WEST SUSSEX COUNTY COUNCIL CONSULTATION

TO:	Arun District Council FAO: Mrs A Gardner
FROM:	WSCC - Highways Authority
DATE:	27 April 2021
LOCATION:	Paddock House 44 Ferringham Lane Ferring BN12 5LU
SUBJECT:	FG/50/21/PL Variation of condition approved under FG/115/17/PL relating to condition 2-plans condition. This site is in CIL Zone 4 and is CIL Liable as new dwellings.
DATE OF SITE VISIT:	n/a
RECOMMENDATION:	Advice
S106 CONTRIBUTION TOTAL:	n/a

Refuse Vehicle and Fire Tender
Turning Swept Path Analysis

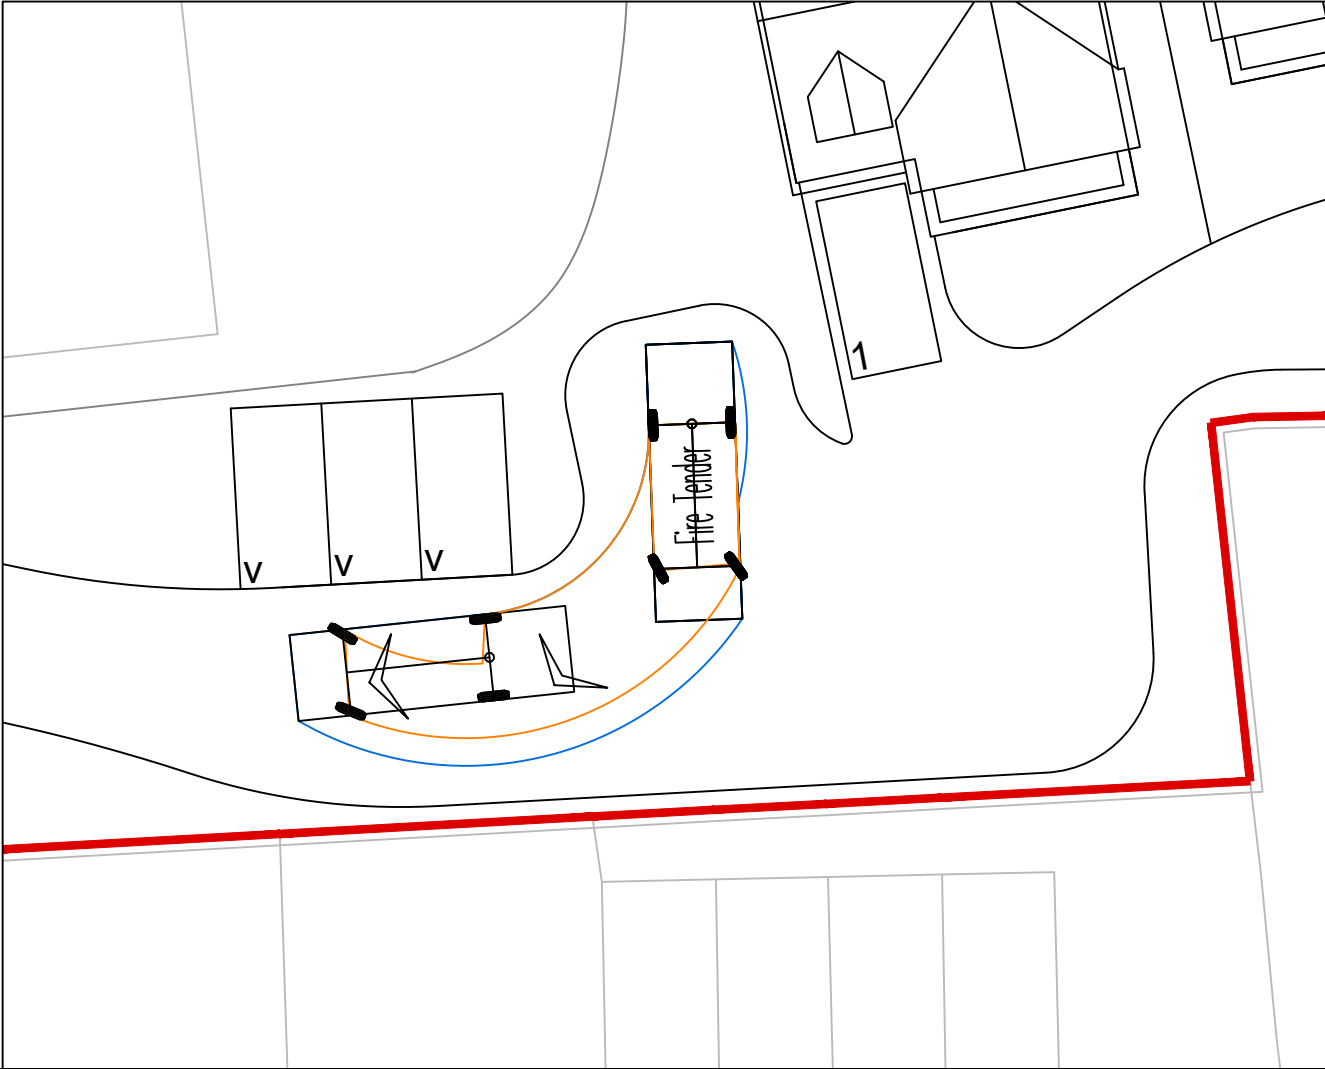
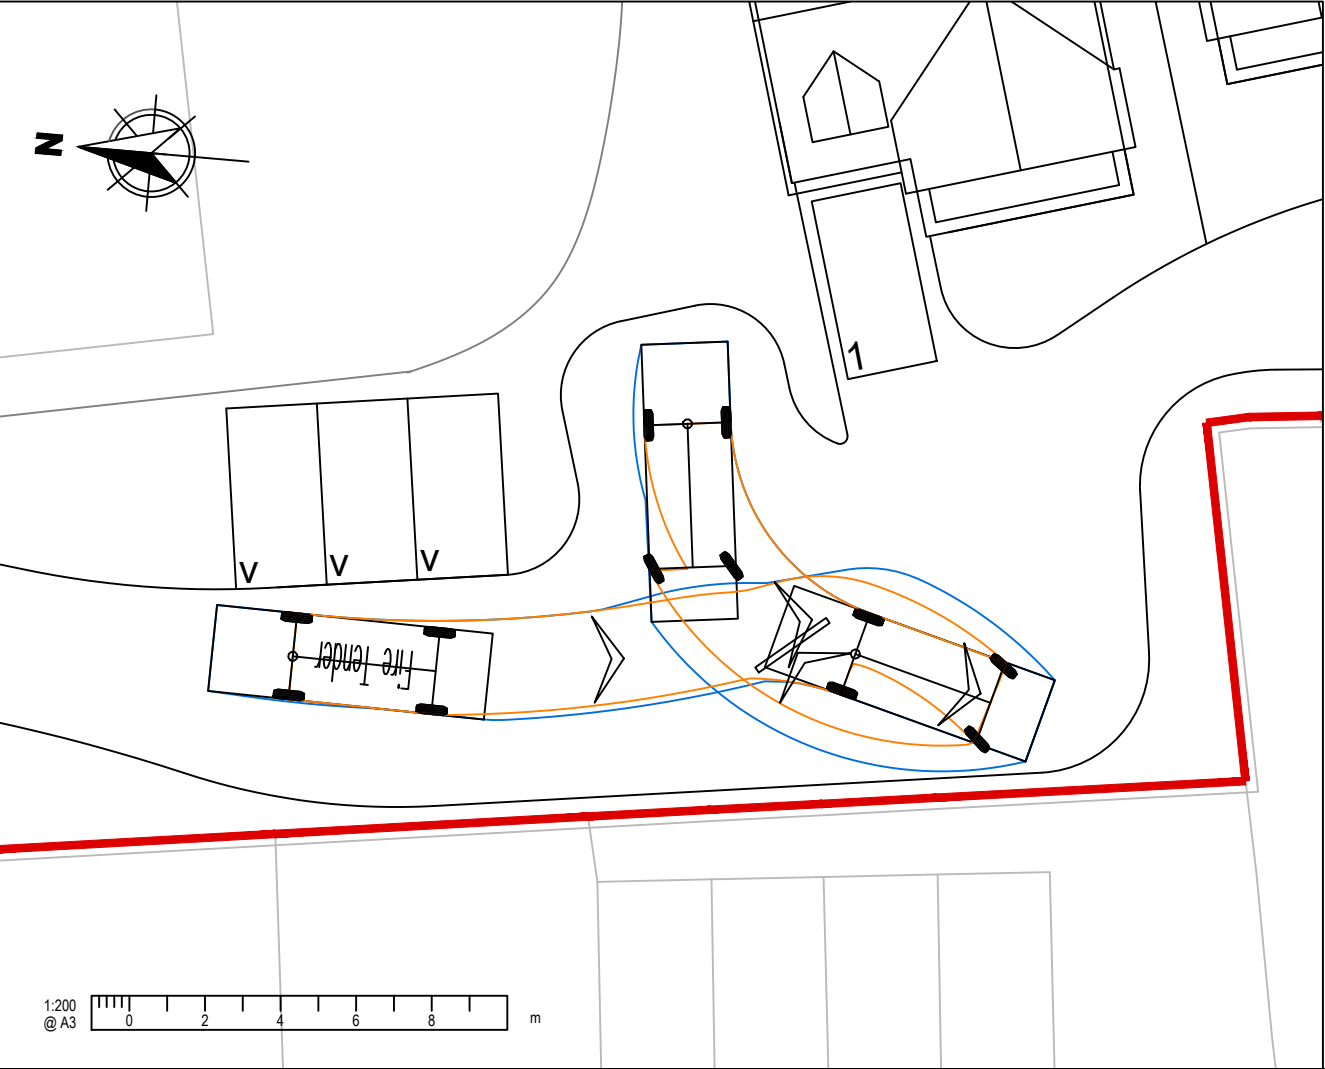
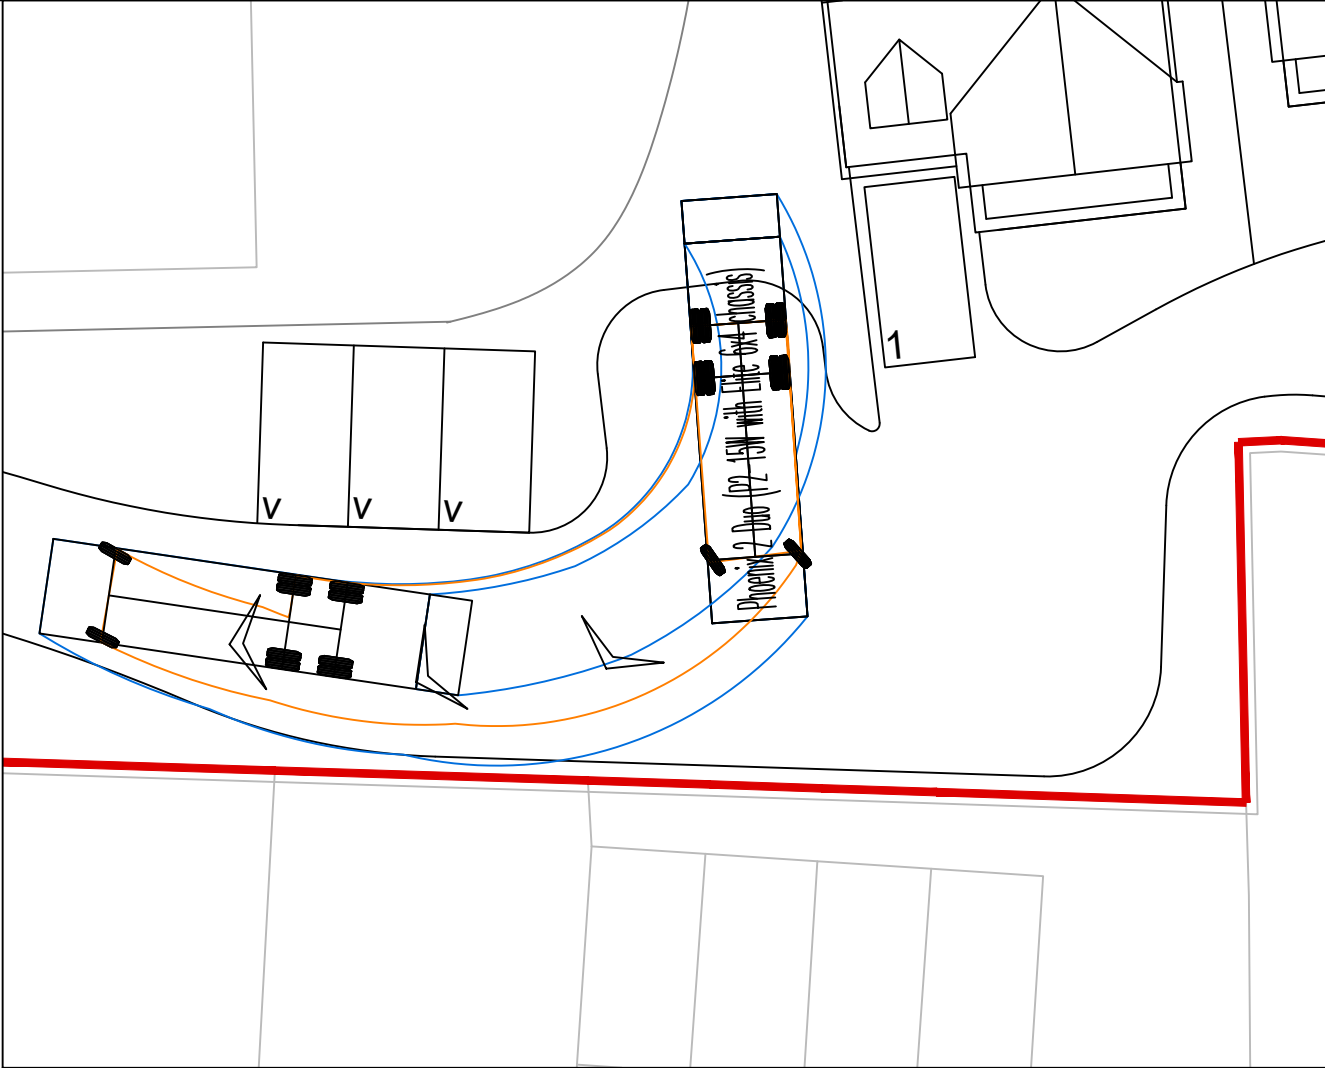
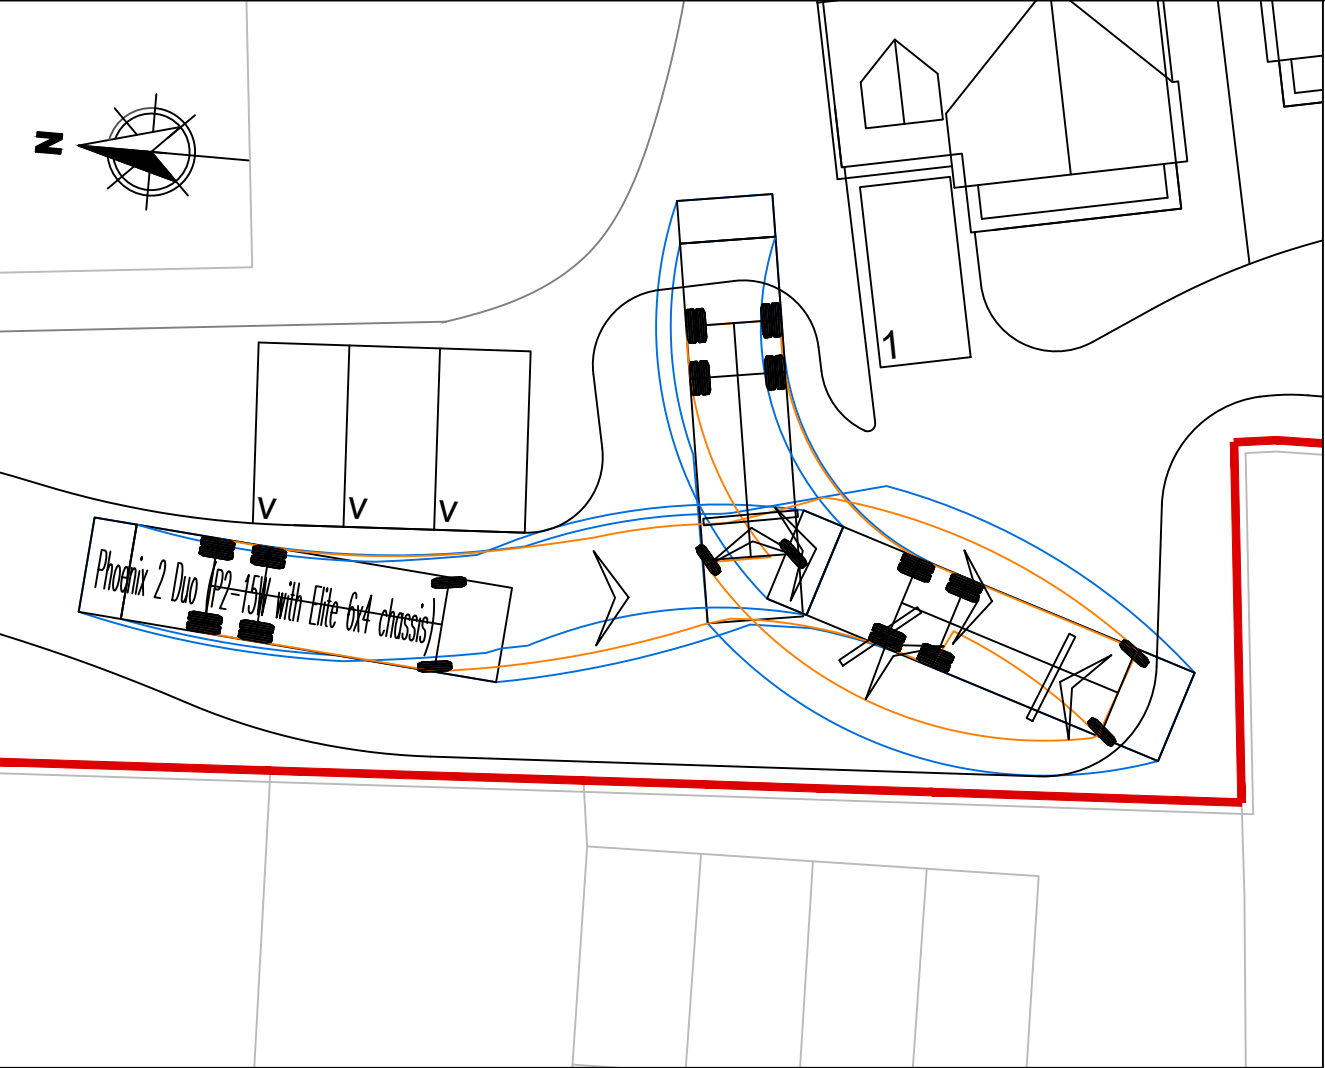
An area for the turning of fire appliances and refuse lorries has been annotated on the proposed site plan, 2007 2.05 Revision B. The annotation details that plans 2020-6201 002 and 003 prepared by Bright Plan detail this area, presumably with swept path tracking.

It does not seem that plans 2020-6201 002 and 003 are available on the Arun DC Planning Portal for inspection. While it seems that this area is broadly similar to that being demonstrated as suitable for turning of such vehicles under FG/115/17/PL it would be beneficial if the plan can be made available for review by WSCC Highways and WSCC Fire Water and Access.

In conclusion the Local Highways Authority has no in principle concerns with the proposed revised plans. However, in the interests of completeness it would be requested that plans 2020-6201 002 and 003 prepared by Bright Plan are made available for scrutiny.
